Your Ref: LU/121/17/RES

Our Ref: PE/ARU/17/17/A

Re: Land North of Toddington Lane, Parcel C1 & part Parcels B2 B4 & C2 Littlehampton, BN17 7PP.

Thank you for your correspondence of 19th April 2017, advising me of a planning application for approval of reserved matters following outline consent LU/47/11/ for construction of 126 No. dwellings together with internal road network, car parking & landscaping at the above location, for which you seek advice from a crime prevention viewpoint.

Site:	Phase 2 Littlehampton	Date:	February 2017
Scale:	1:500 @ A1		
Dwg No:	543_PL_SITE LAYOUT_100

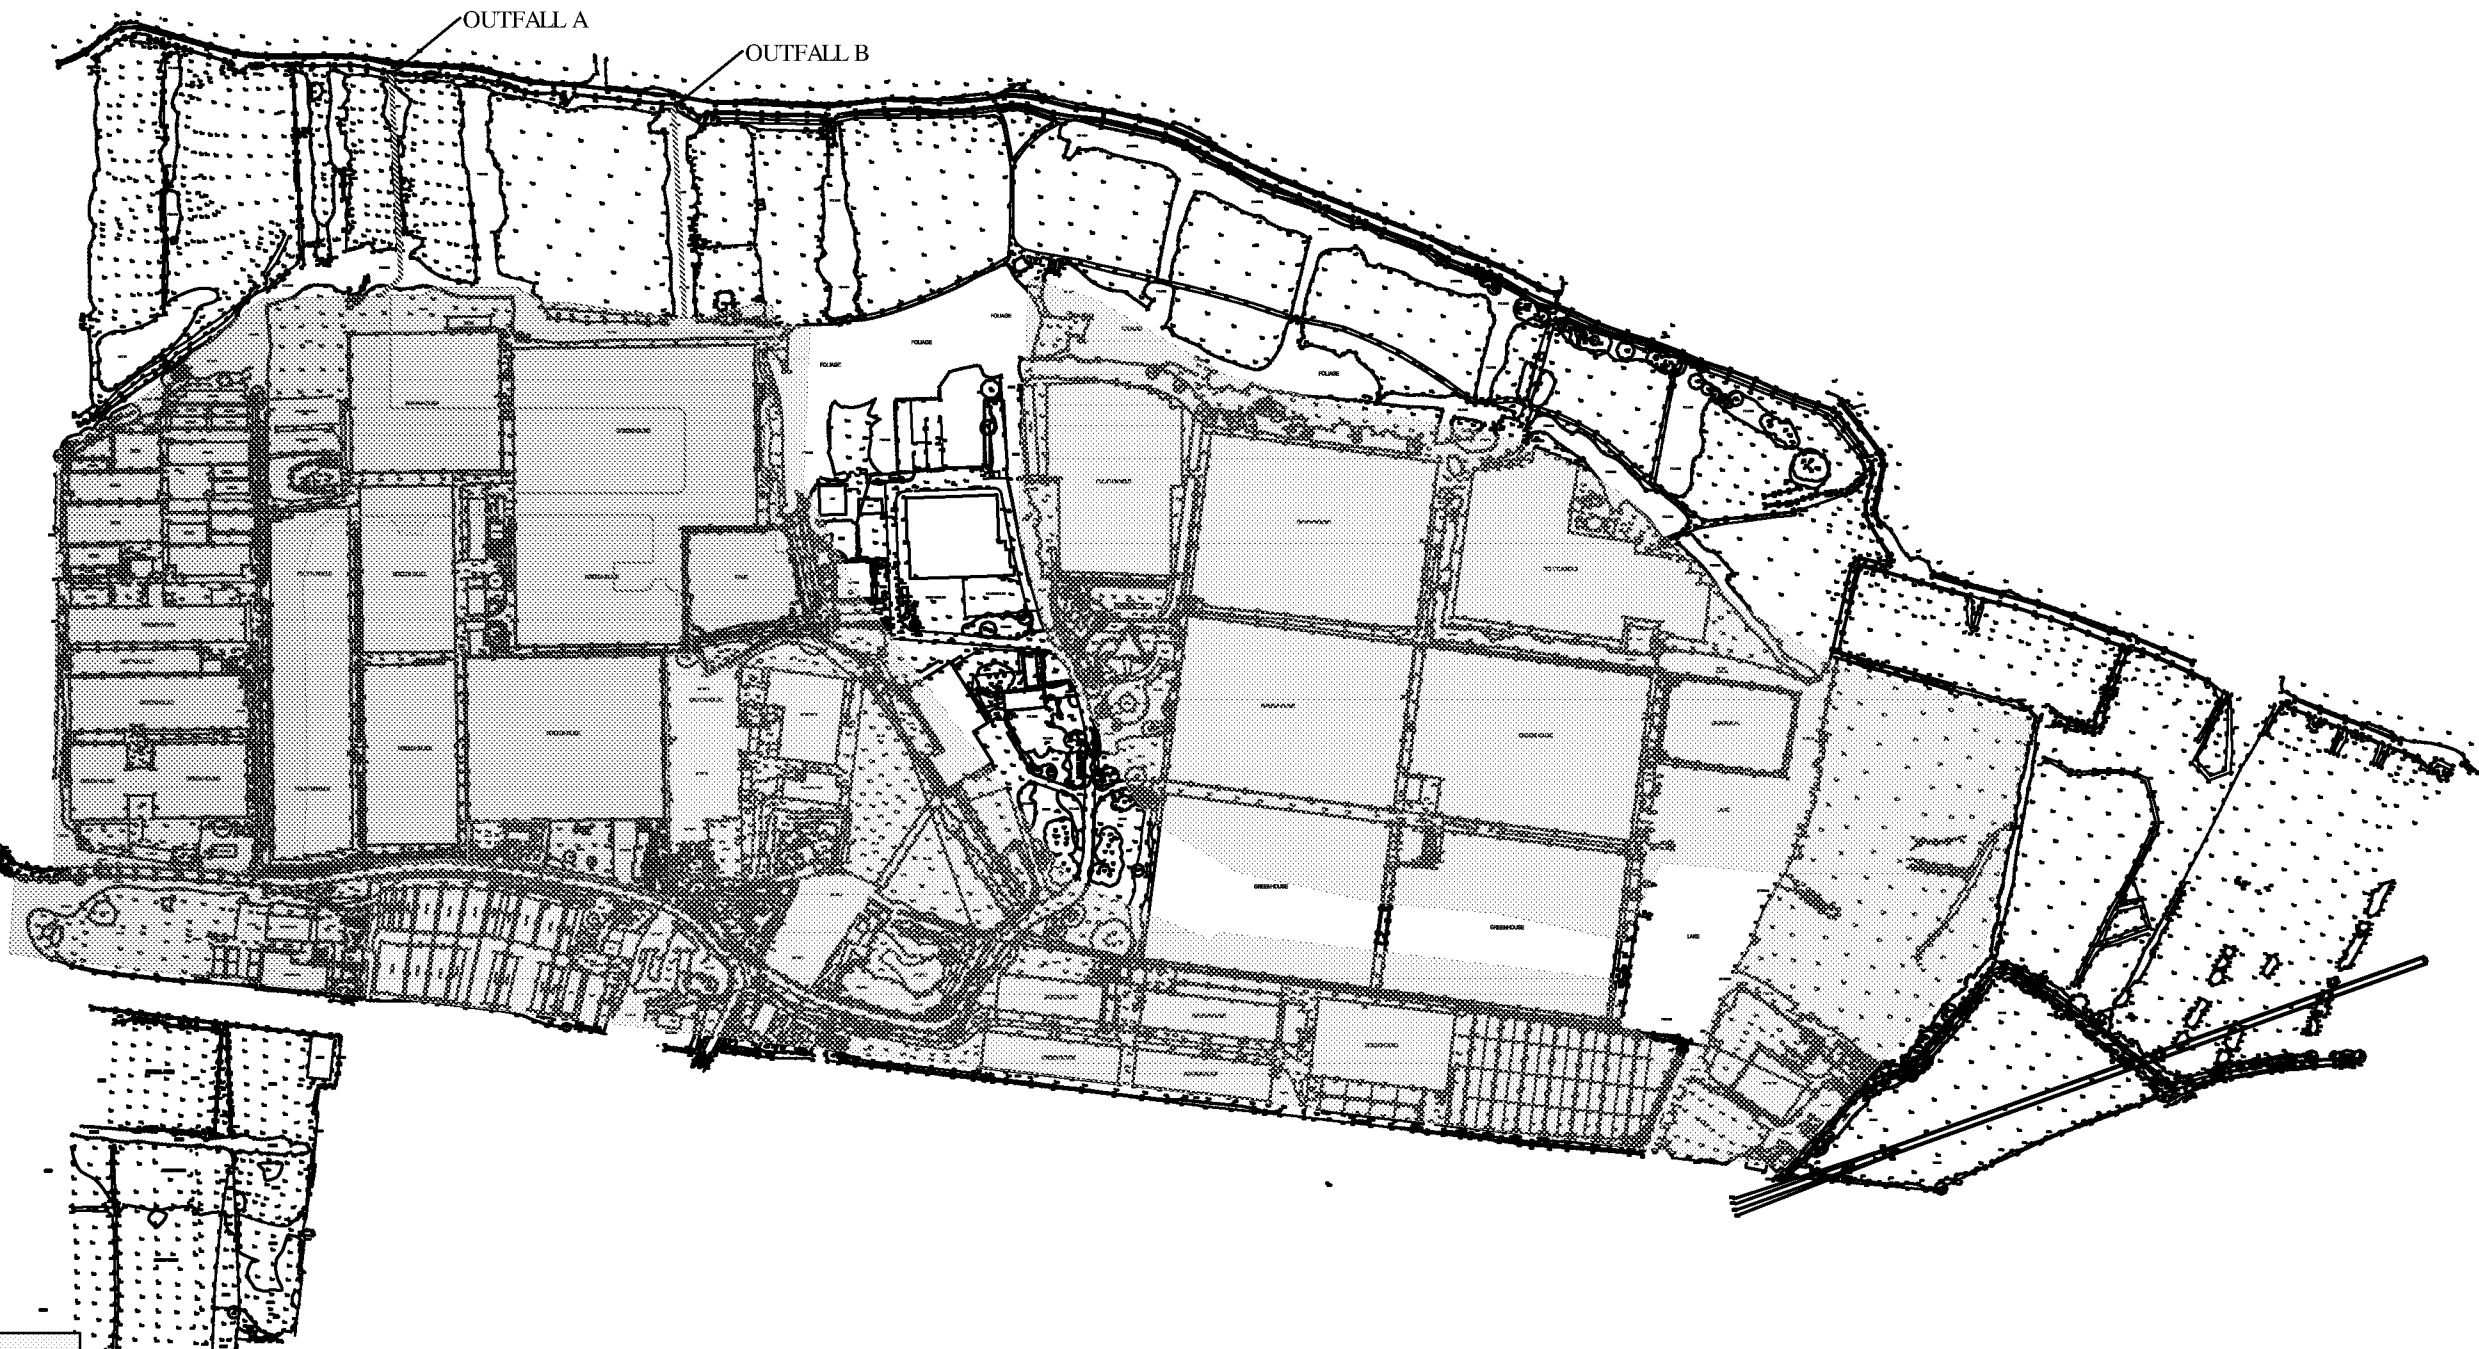
Parking in the main has been provided with in-curtilage, garage, overlooked bays and a number of on street parking bays, this should leave the street layout free and unobstructed. I am concerned about the garage and in-curtilage parking provided for plot 101, this area has no observation over it at all. This is replicated for plot's 55 & 65 in curtilage parking bays, they are not overlooked or have any observation over them. The communal block, plots 95 – 100 must have good observation over their rear parking court. Where communal parking occurs it is important that they must be within view of an active room within the property. An active room is where there is direct and visual connection between the room and the street or the car parking area. Such visual connections can be expected from rooms such as kitchens and living rooms, but not from bedrooms and bathrooms. Gable ended windows can assist in providing observation over an otherwise unobserved area.

Hard Landscape LA107

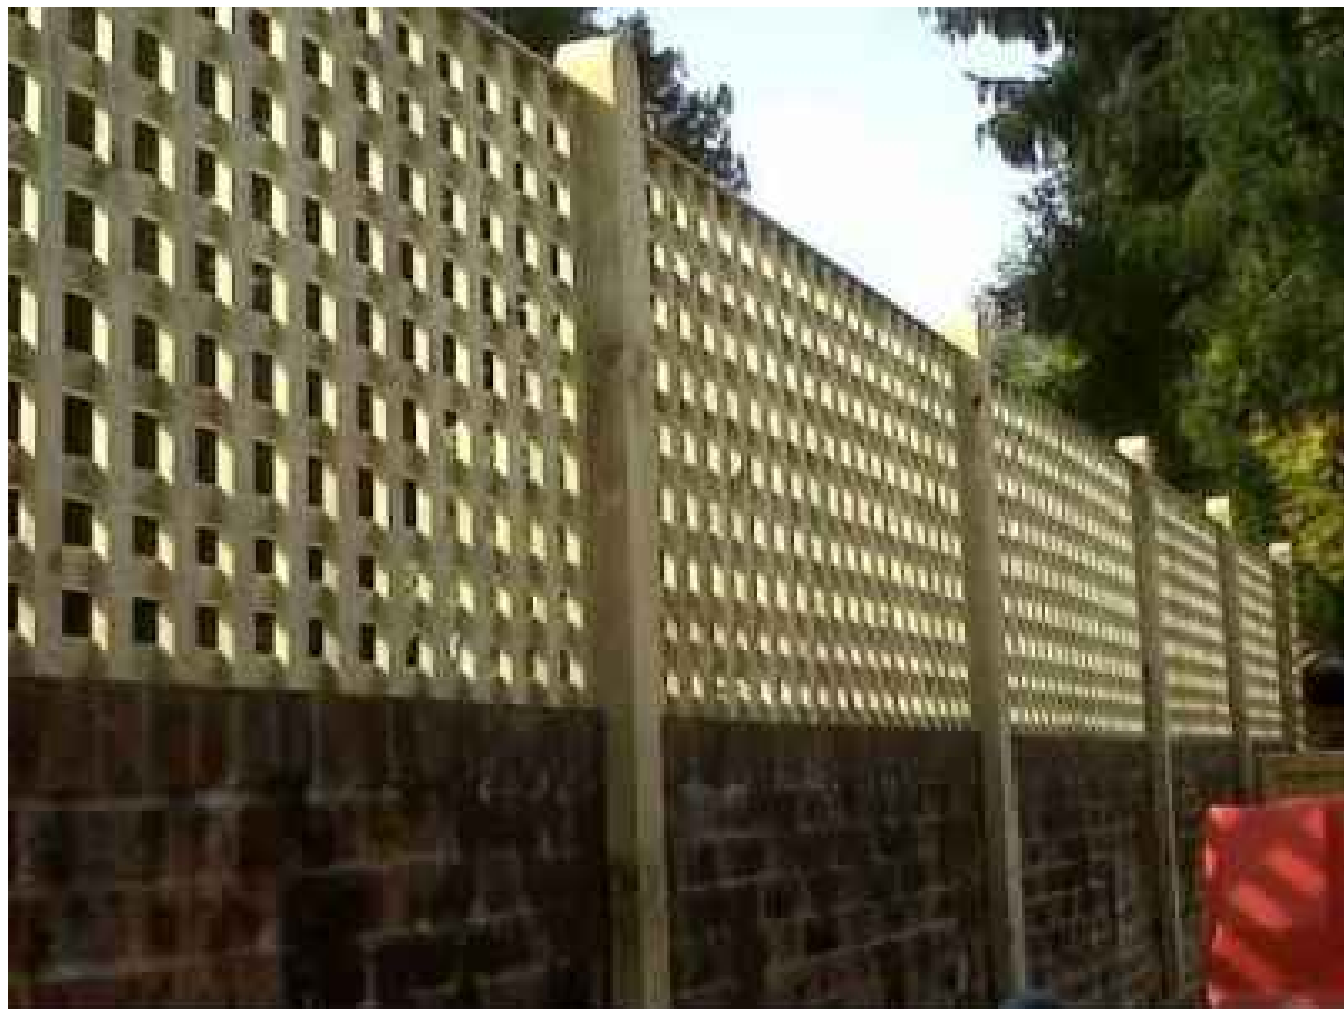
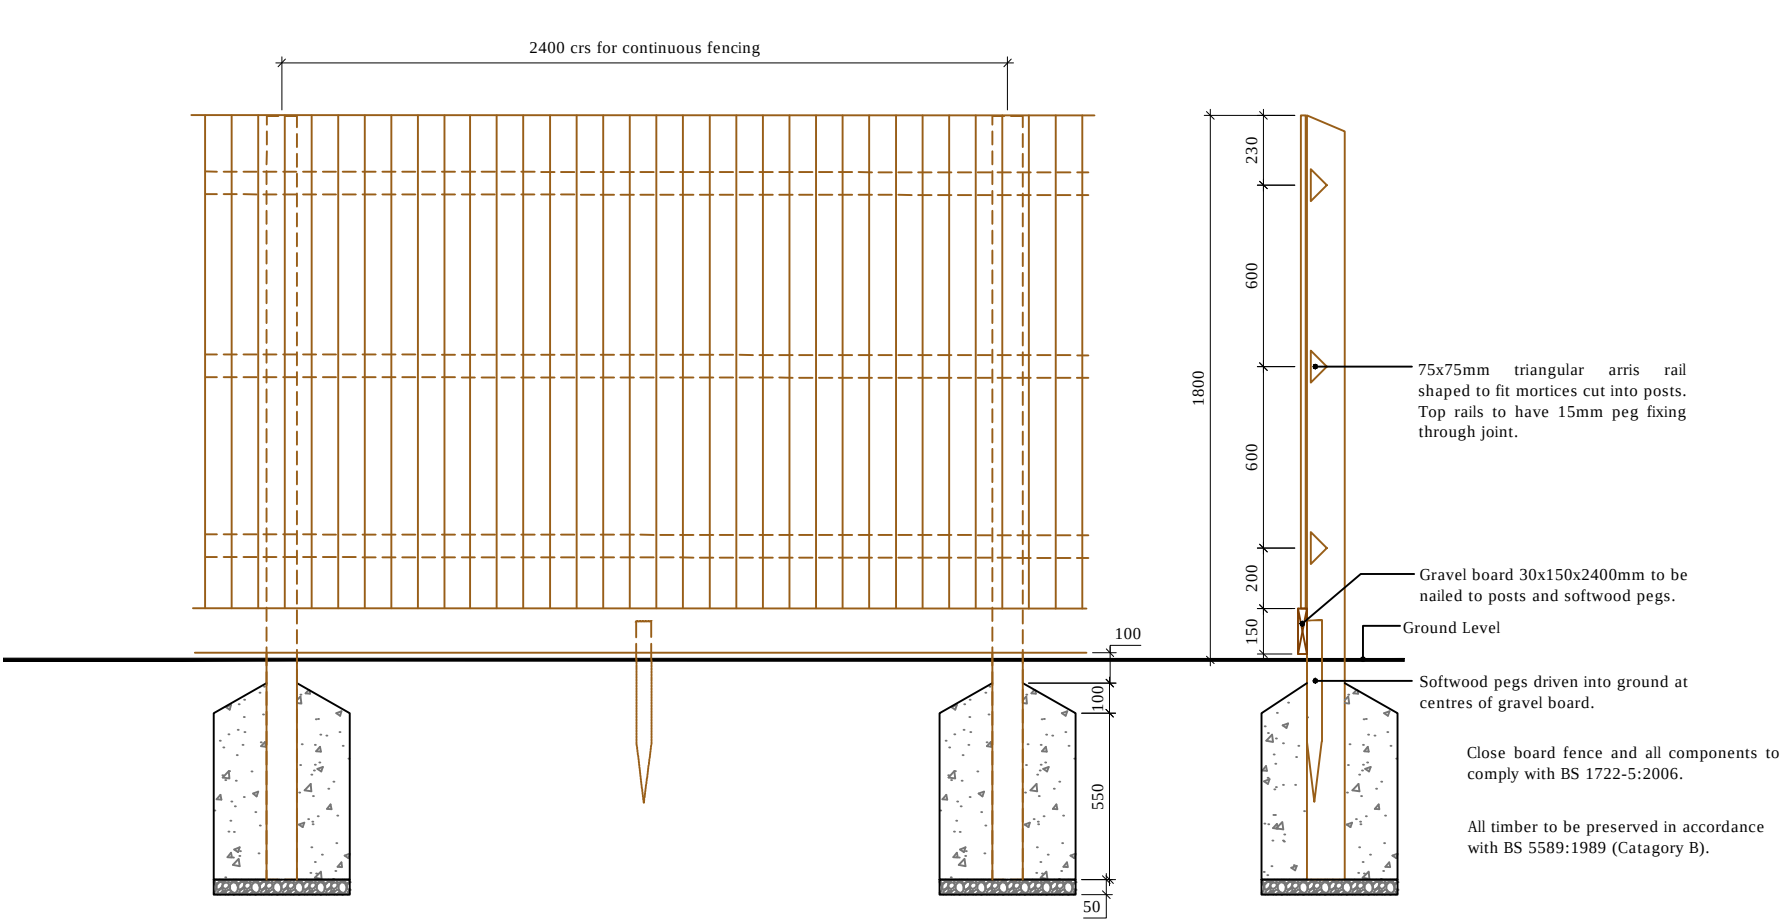
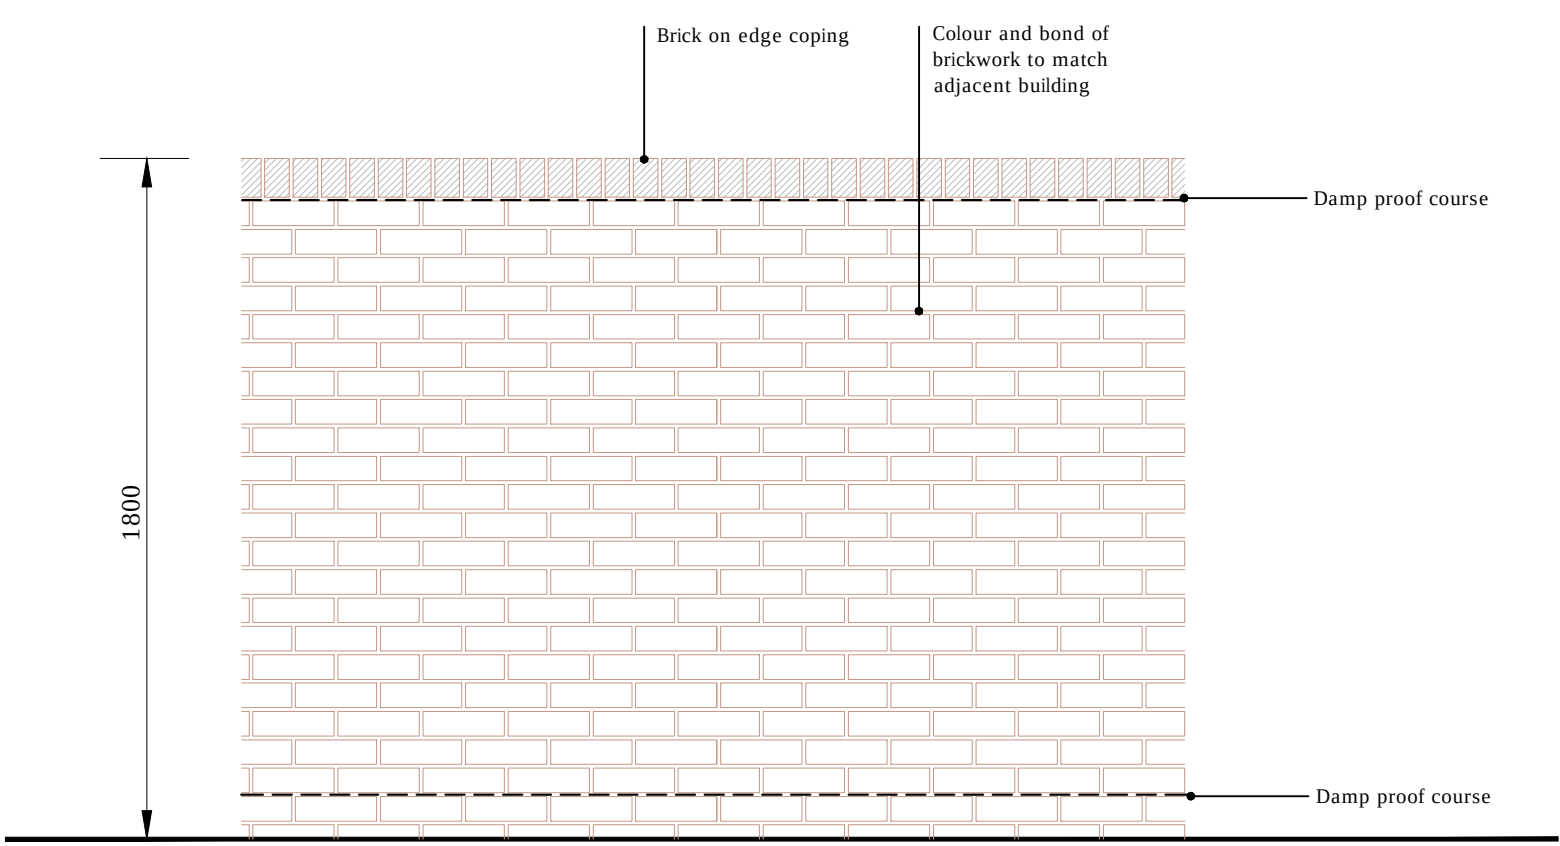
As the first line of defence, perimeter fencing must be adequate with vulnerable areas such as side and rear gardens needing more robust defensive barriers by using walls or fencing to a minimum height of 1.8metres. I note that the development's perimeter is designated as having 1.8 metre high close board fencing, this must however be extended to the dwelling's boundary fencing as well.

In circumstances that require a more open feature such as a garden overlooking a rear parking court or a rear garden pathway, 1.5metre high close board fencing topped with 300mm of trellis can achieve both security and surveillance requirements. This solution provides surveillance into an otherwise unobserved area and a security height of 1.8 metres.

Gates that provide access to the side of the dwelling or rear access to the gardens must be robustly constructed of timber, be the same height as the adjoining fence and be lockable from both sides. Such gates must be located on or as near to the front of the building line as possible. An example of this would be for plot's 5, between plots 7 – 8 & 9 – 10 and plot 12. This will remove the opportunity for loitering and remove easy unauthorised access to the rear of the properties which otherwise would make it vulnerable.
